Online Comment

Application H18-0671-19
Location 36 PETTS LANE SUTTON BRIDGE SPALDING PE12 9QB
Proposal Extension and alterations of existing house. Existing outbuilding to be converted into annexe and buildings linked together with a link building

Name Ian Marshman, Historic Environment Officer
Address Lincolnshire County Council Lancaster House 36 Orchard Street LN1 1XX

Date Submitted 01-08-19
For/Against Comments

PROPOSED EXTENSIONS AND ALTERATIONS
TO HOUSE AND OUTBUILDINGS AT
36 PETTS LANE SUTTON BRIDGE FOR
THE BUNN FAMILY

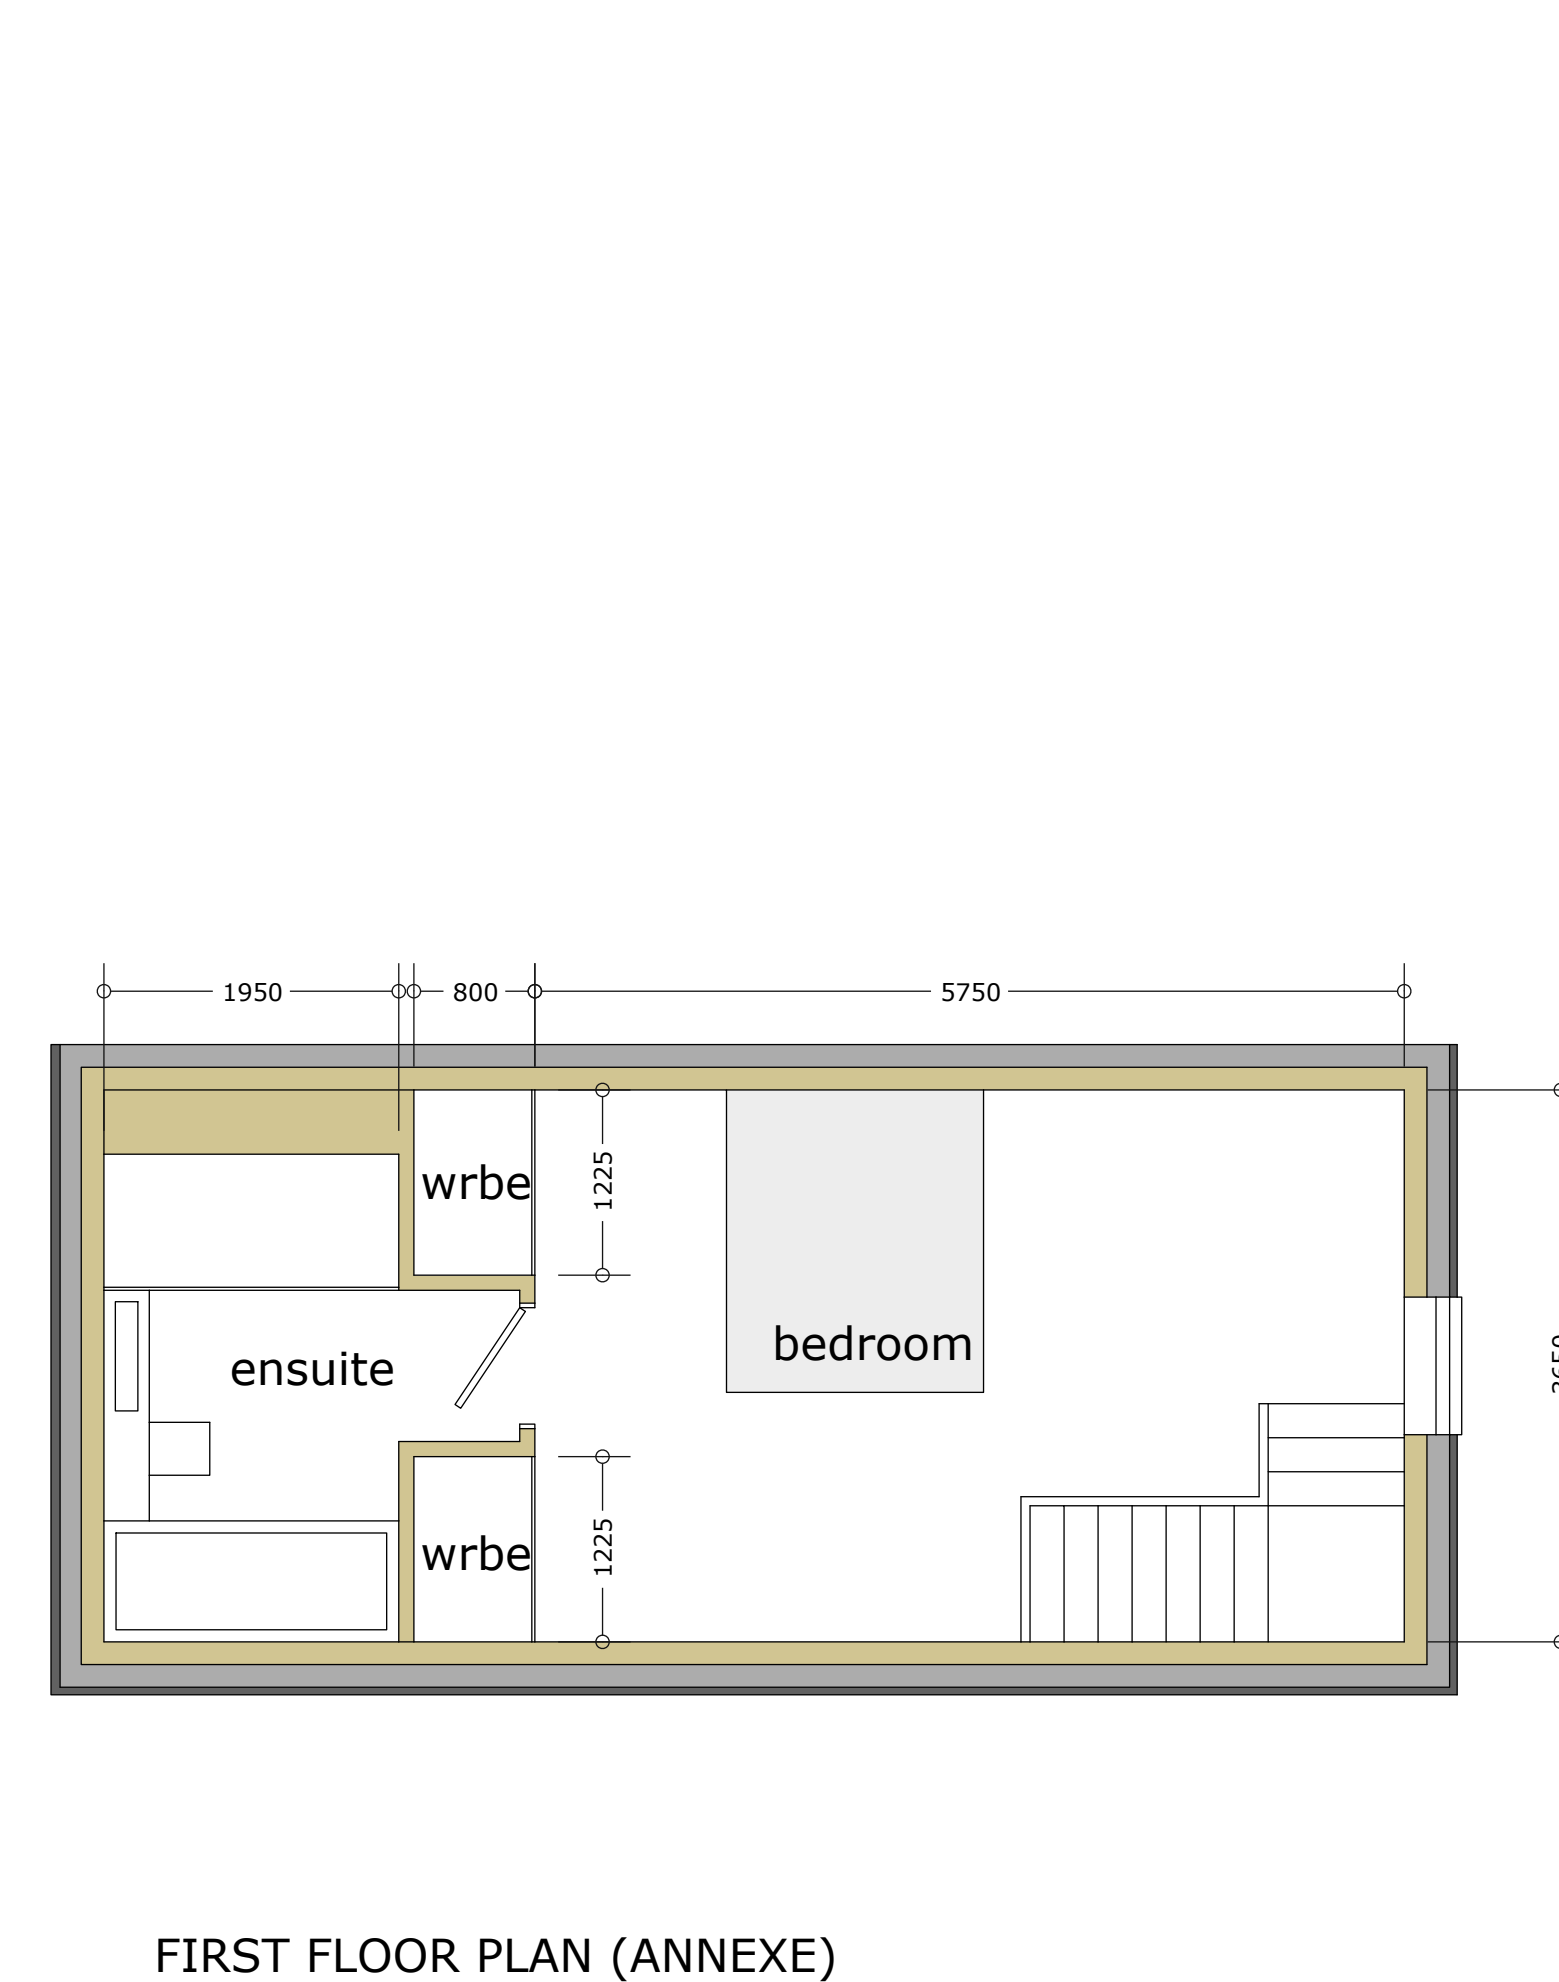
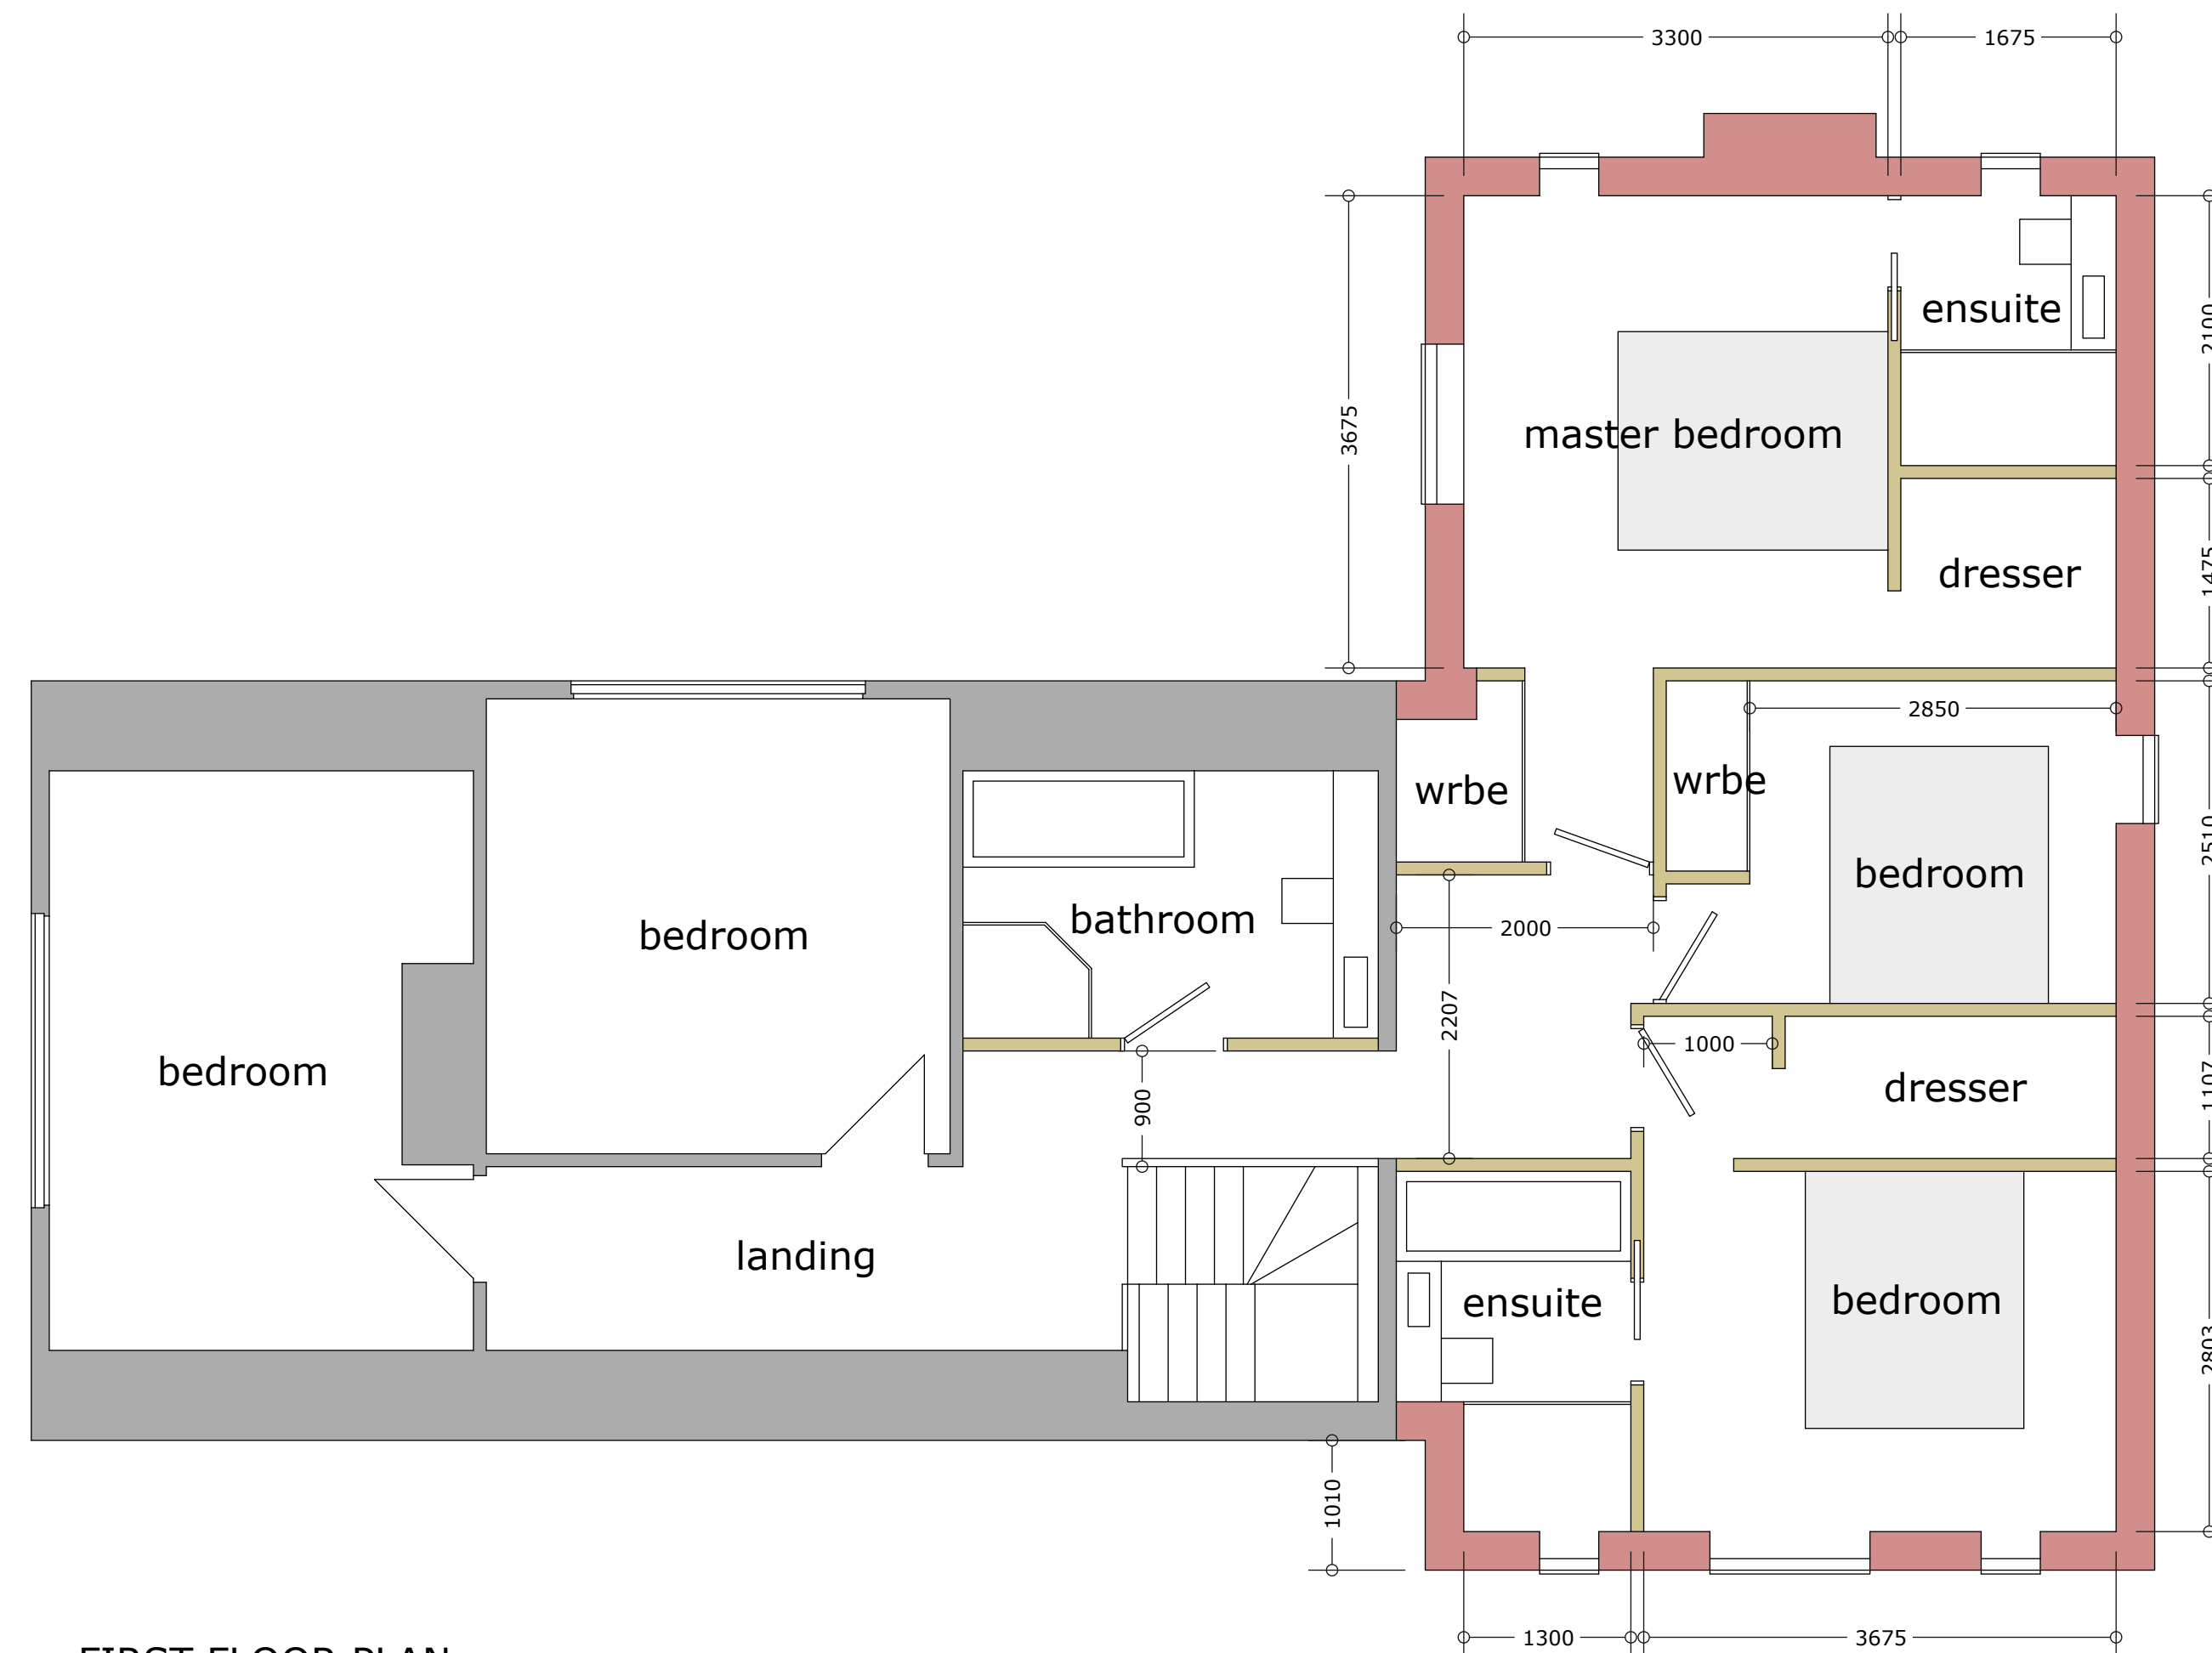
The present proposals involve the conversion of the original barn from the small holding, and a substantial new extension in the form of a projecting wing of modern design, as well as reordering and replacement of windows and doors, and the removal of one of the pair of chimneys on the original cottage. This would result in the new extension dominating the historic cottage and smallholding, to the extent that its historic character would no longer be legible, leading to an almost total loss of significance.

Cumulatively these alterations and the new render would result in the cottage taking on the appearance of a single wing of a new build executive home, which reflects neither the site's heritage, agricultural character or rural location. This is not in accordance with Policy 29 of the South East Lincolnshire Local Plan:

It is recommended that the developer work with the district's Conservation Officer to amend the proposals to better preserve the building's significance, and ensure that the new extension is sensitive to the design, detailing and setting of its historic host dwelling.
